Ribble Valley Borough Council  
By email

**Your ref:** 3/2022/1039  
**Our ref:** 3 DC/22/3994 V5  
**Date:** 18-JUN-2025

**Location: Land adjacent to 115 Kemple View Clitheroe BB7 2QJ**

**Proposal: Proposed construction of two new detached dwellings with associated access and garden areas**

APPENDIX A – Proposed Drainage Strategy

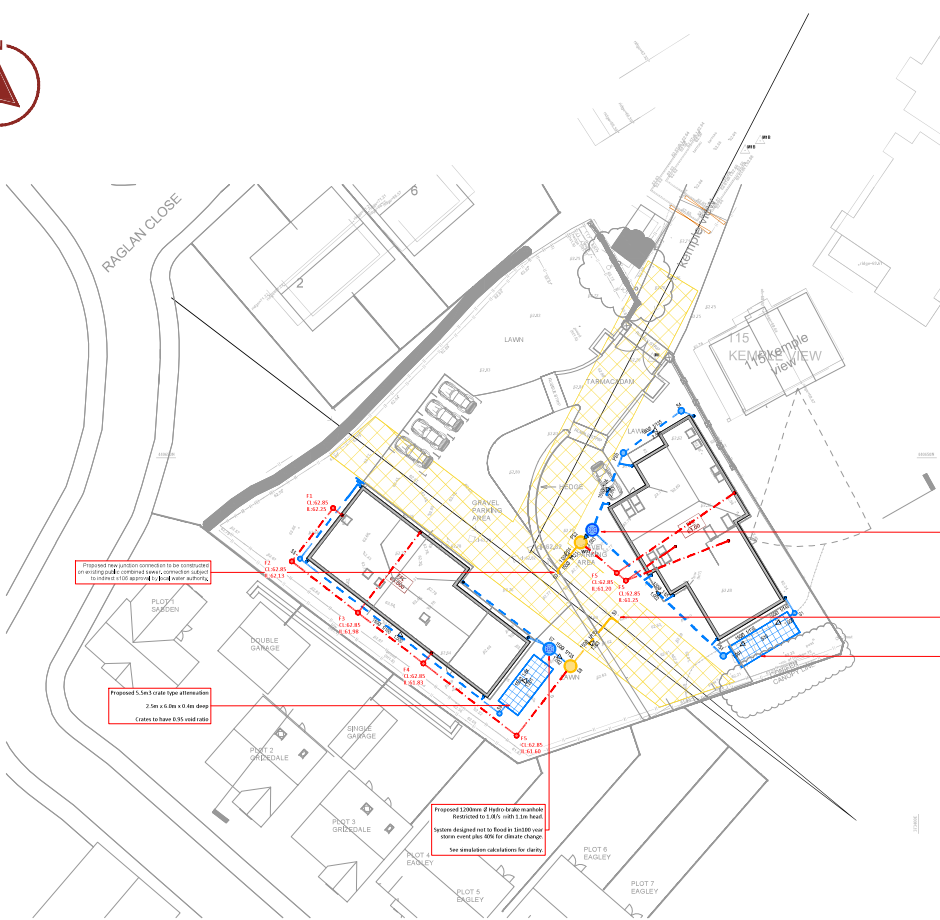
Whilst a new Drainage Strategy has been submitted, no additional information has been provided to demonstrate that the existing sewers which cross the site have been surveyed. This has been requested in our previous responses. We request that a survey is undertaken to confirm the exact location of the sewers which cross the site and the results are submitted as part of this planning application. As this is an application for full planning permission, the location of the sewers will have a bearing upon the proposed layout, for which planning permission is being sought.

Where additional information is requested to enable an assessment of the proximity of proposed development features to United Utilities assets, **the proven location of pipelines should be confirmed by site survey; an extract of asset maps will not suffice.**

***Should planning permission be granted without the provision of the additional information set out above, which is not our recommended approach, given the full nature of this planning application, we request the following condition is attached to any subsequent Decision Notice. We also request that the currently submitted drainage details are not listed as approved documents on the Decision Notice:***

***Prior to the commencement of development, details of a sustainable surface water drainage scheme and a foul water drainage scheme shall be submitted to and approved in writing by the Local Planning Authority. The drainage schemes must include:***

- (i) An investigation of the hierarchy of drainage options in the National Planning Practice Guidance (or any subsequent amendment thereof). This investigation shall include evidence of an assessment of ground conditions and the potential for infiltration of surface water in accordance with BRE365;***
- (ii) A restricted rate of discharge of surface water agreed with the local planning authority (if it is agreed that infiltration is discounted by the investigations);***
- (iii) Levels of the proposed drainage systems including proposed ground and finished floor levels in AOD;***
- (iv) Incorporate mitigation measures to manage the risk of sewer surcharge where applicable; and***
- (v) Foul and surface water shall drain on separate systems.***

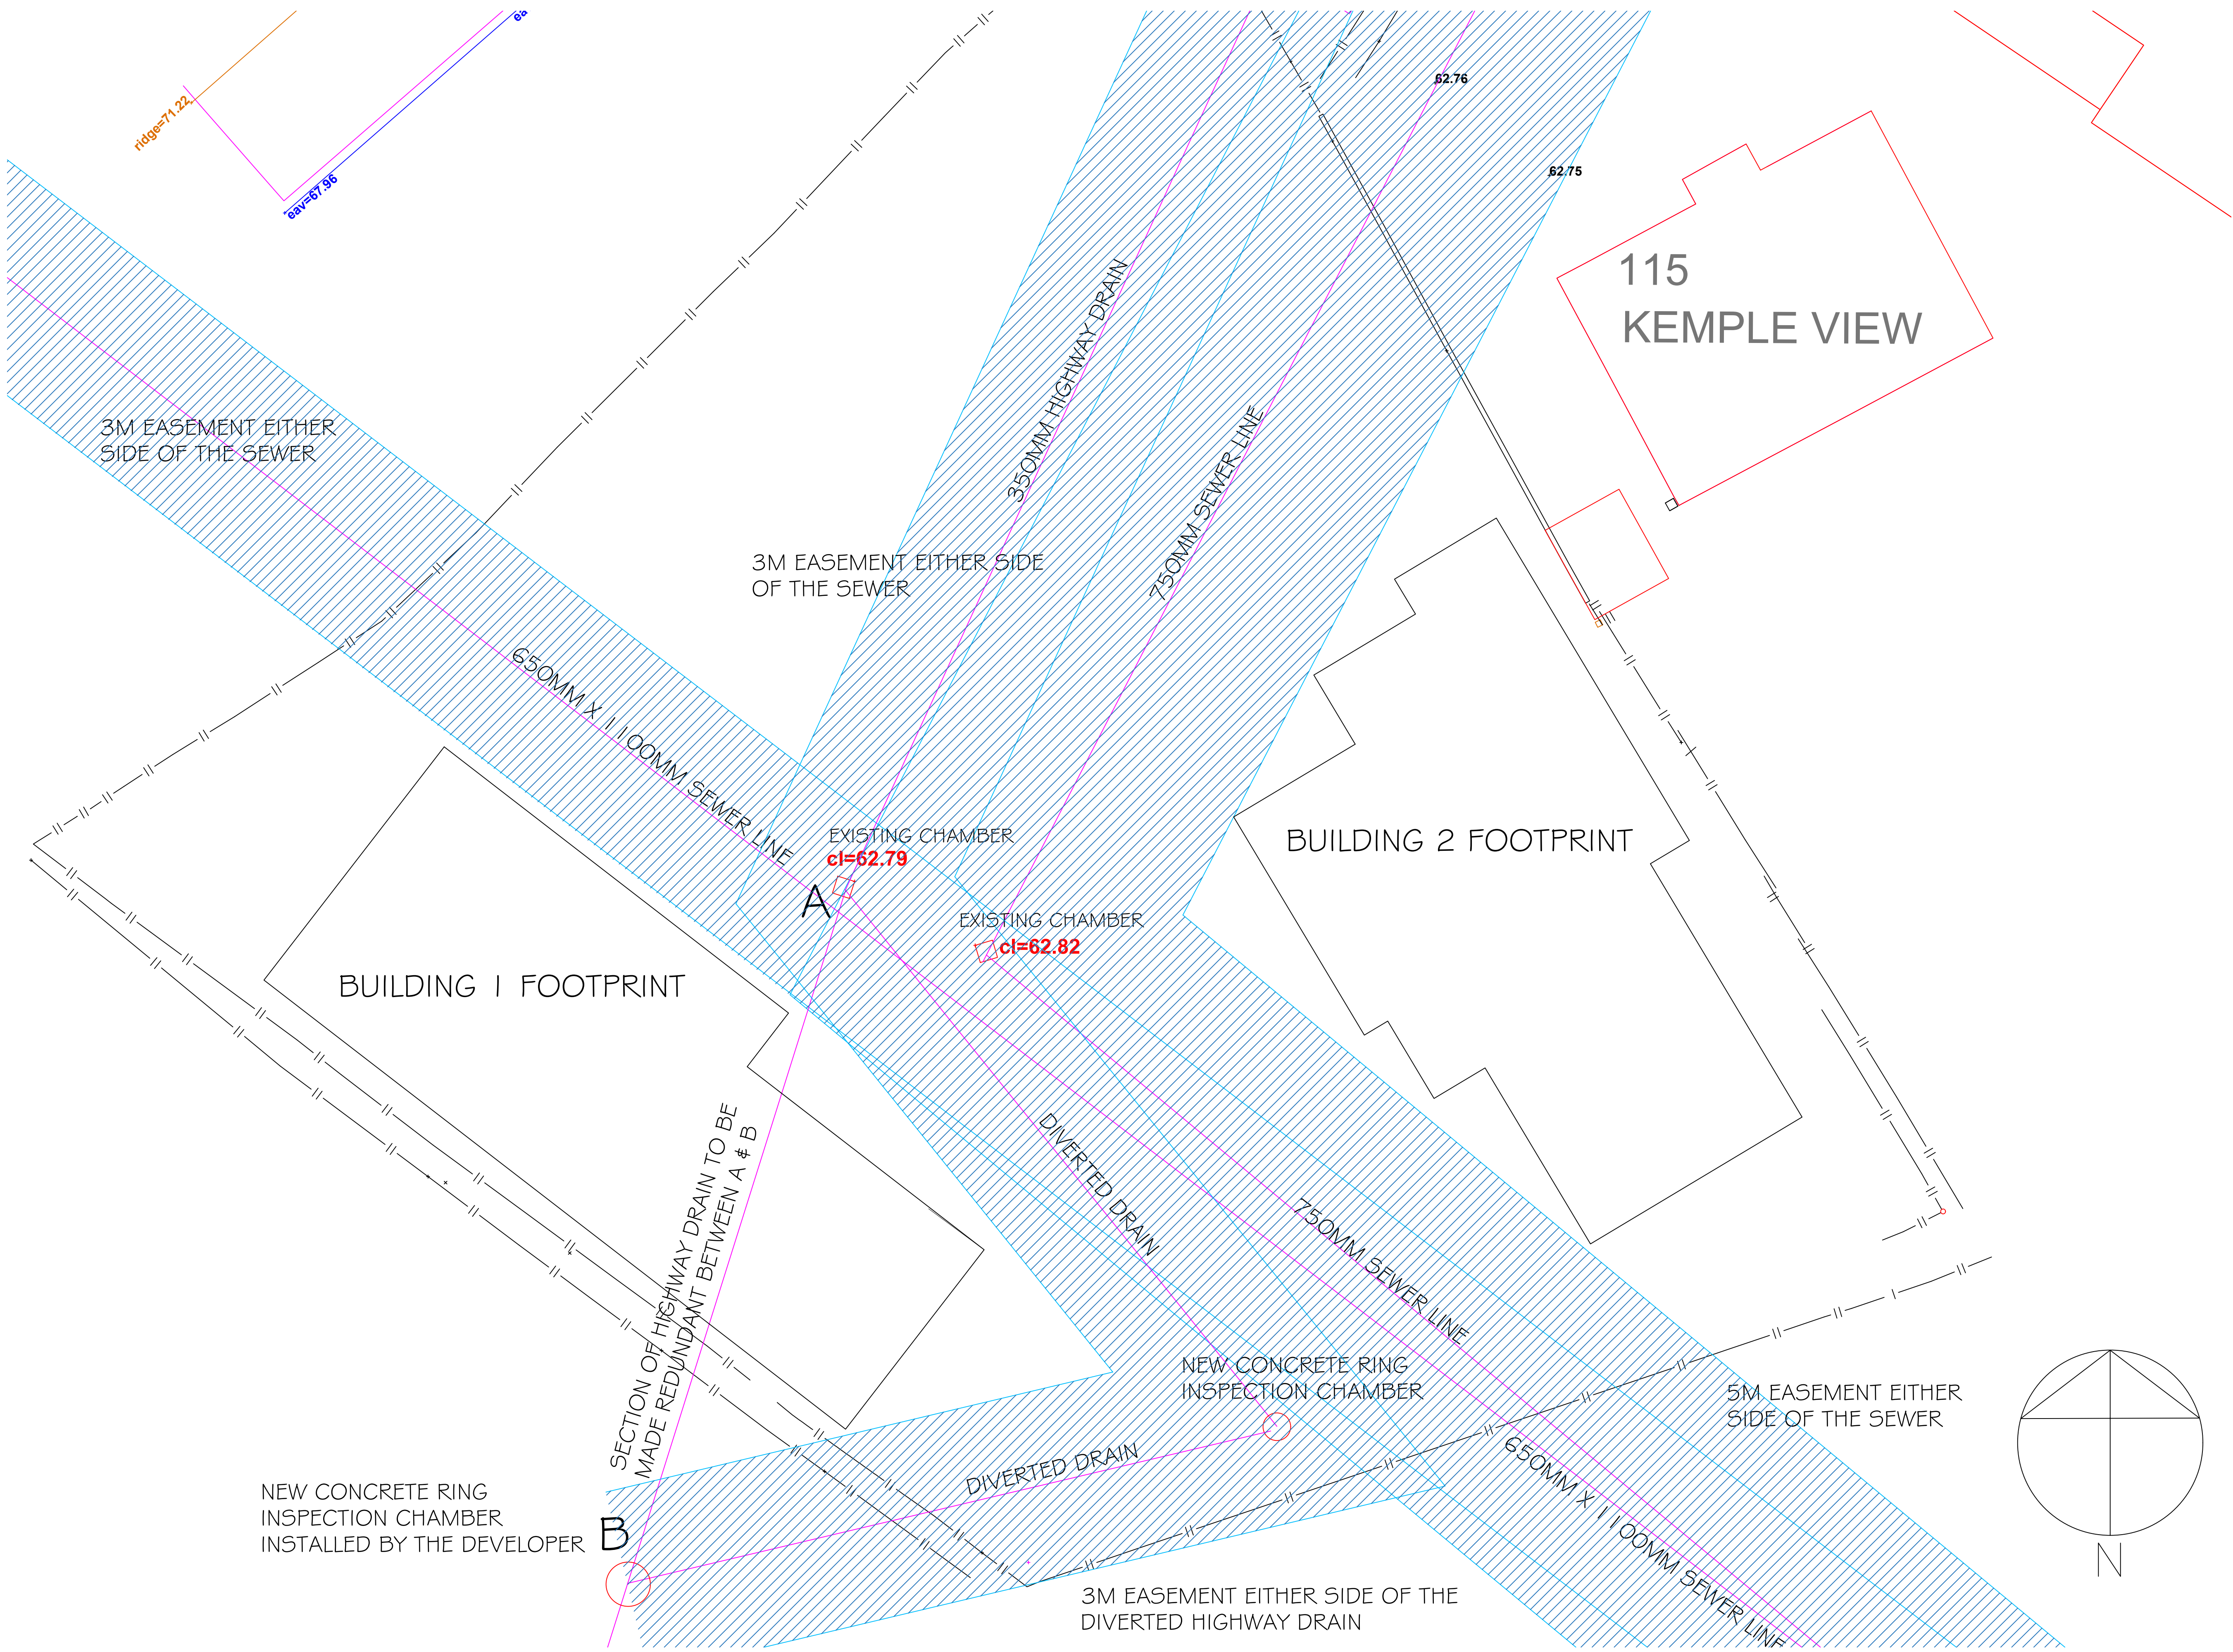
A number of public sewers cross the site and we will not allow building over them. We require an access strip for maintenance or replacement of each sewer and this access must not be compromised in any way. The minimum distances that might be acceptable to United Utilities are detailed within Part H of the Building Regulations however, we recommend the applicant determines the precise location, size, depth and condition of each pipeline as this is likely to influence the required stand-off distance from any structure.
